MECKLENBURG COUNTY
Park and Recreation Department

MEMORANDUM

DATE: September 9, 2021

RE: Rezoning Petition #2021-078 – M/I Homes Ridge Road

SHEET
REZONING PLAN
RZ.01

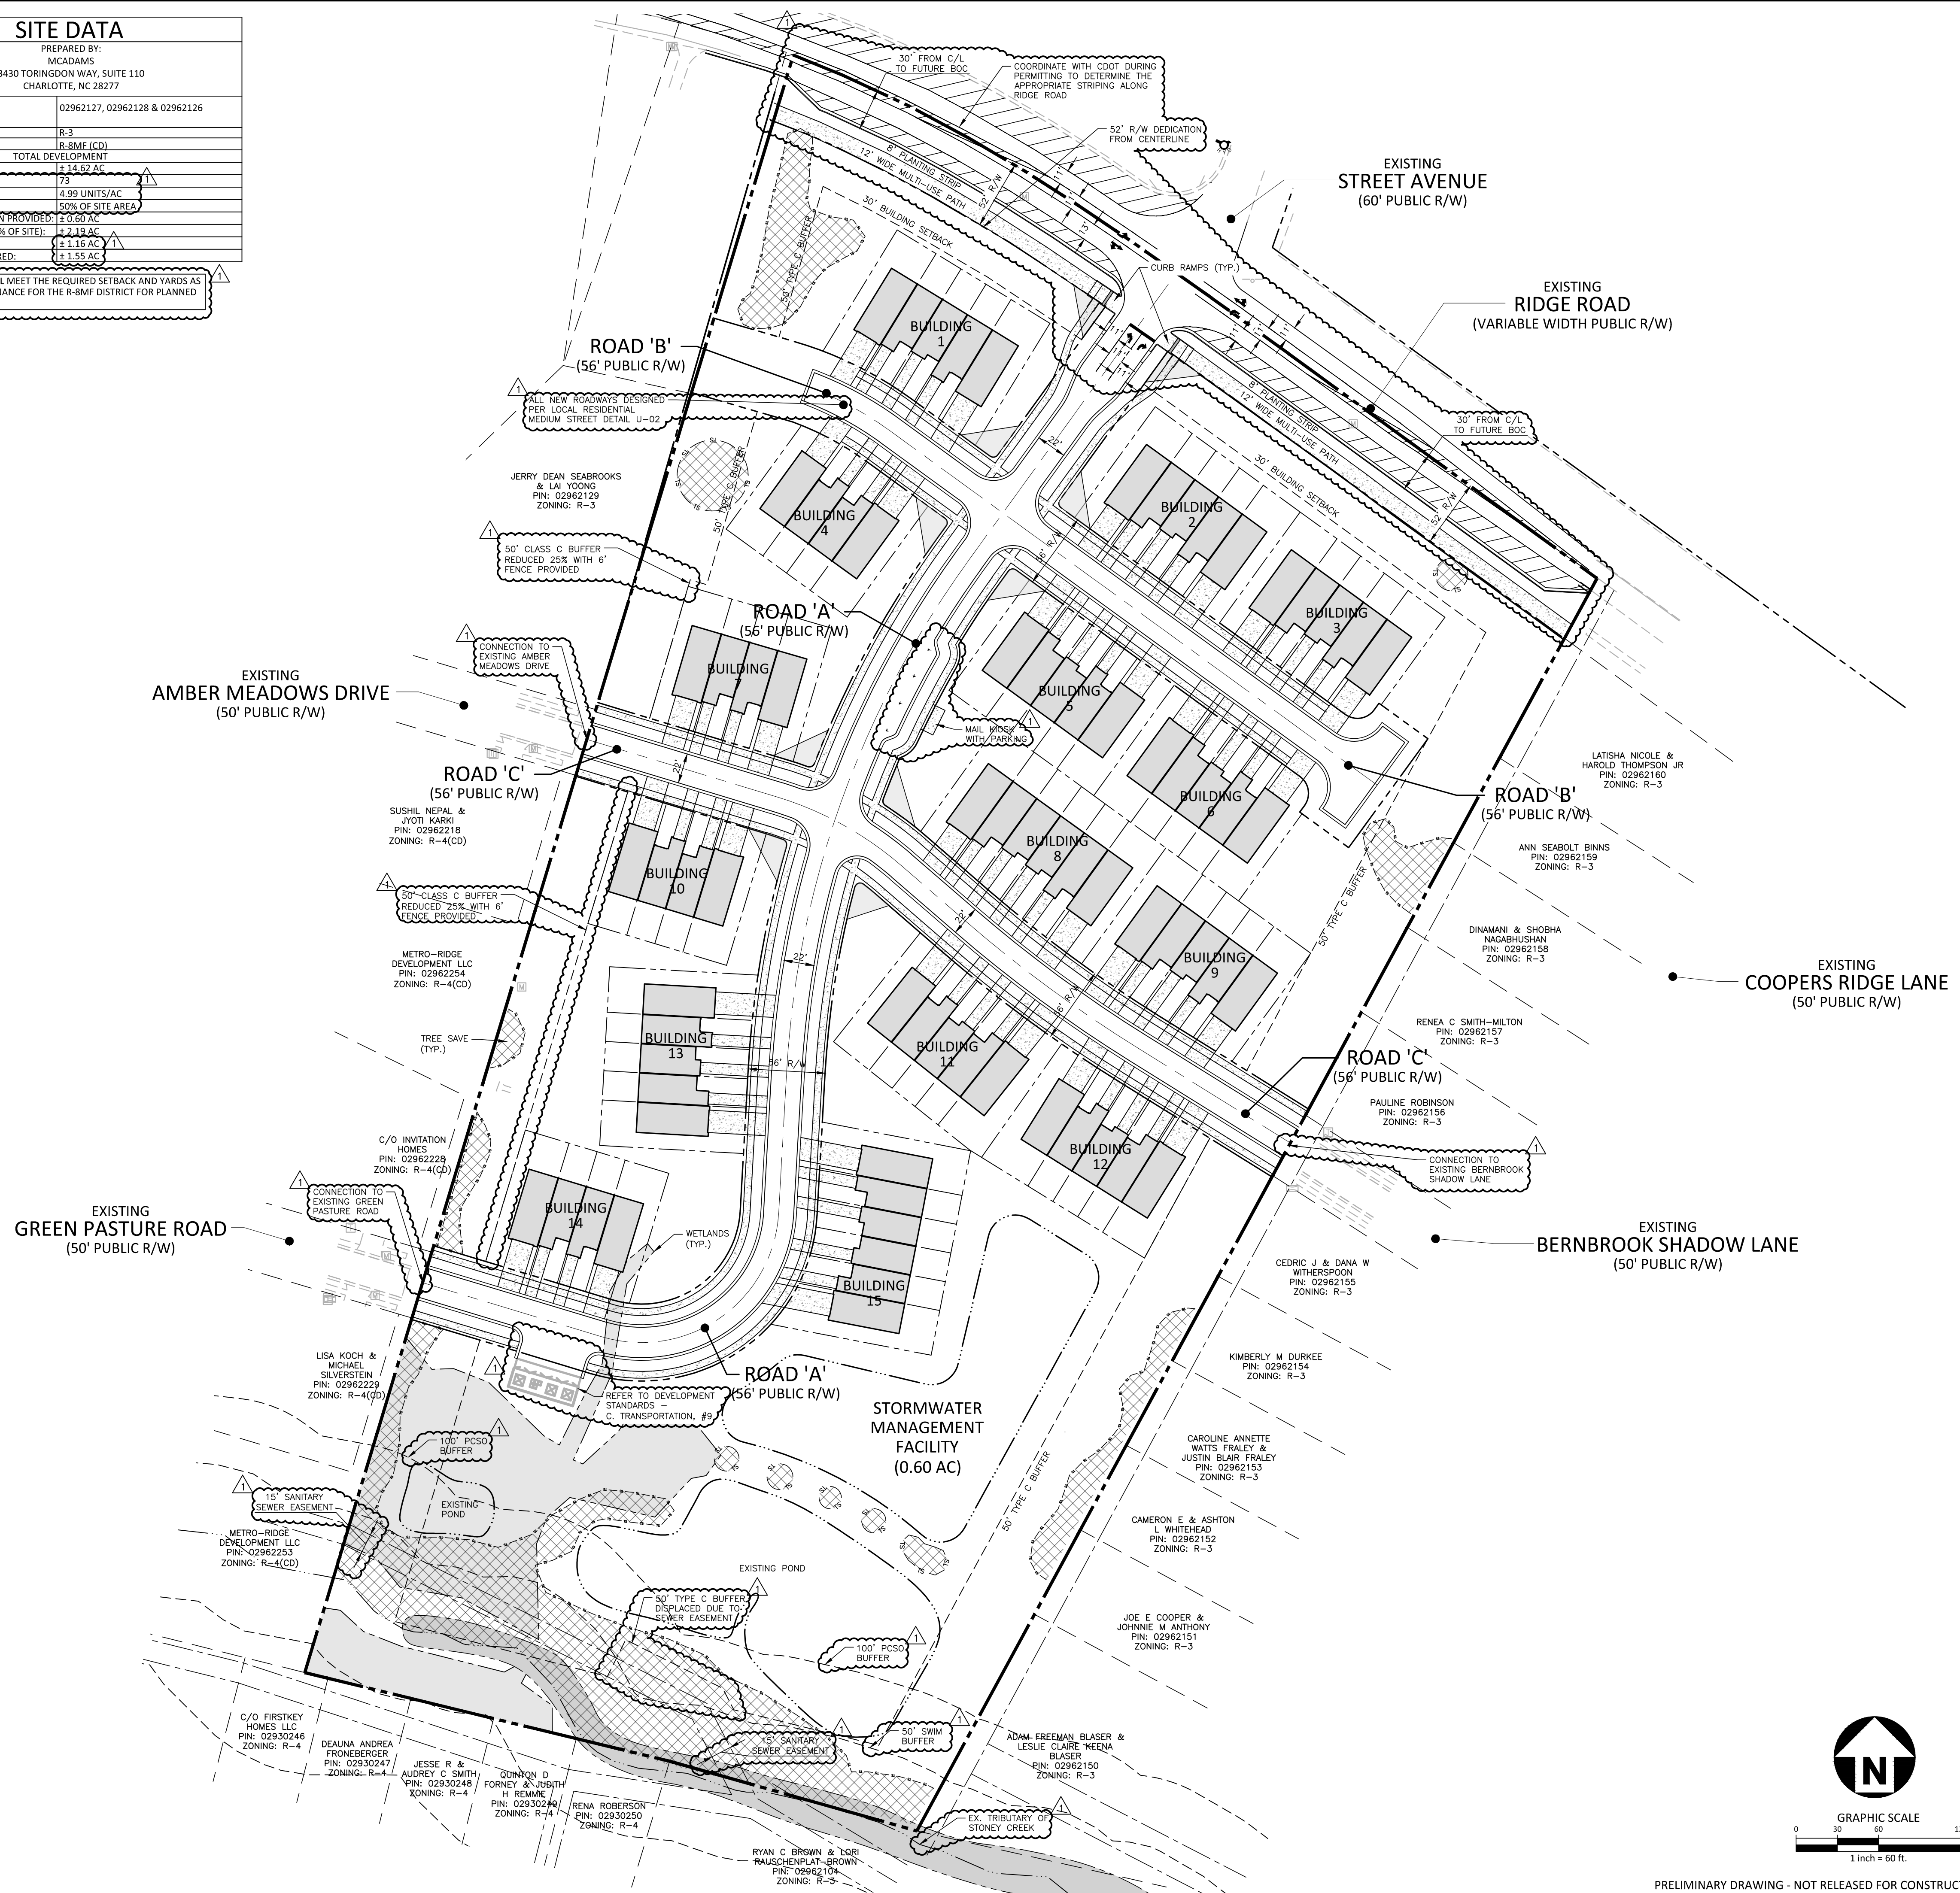
MCPR requests the petitioner dedicating and conveying or providing a greenway easement of the same area to Mecklenburg County - the SWIM Buffer of Stony Creek Trib. This parcel(s) is on the MCPR Greenway Master Plan.
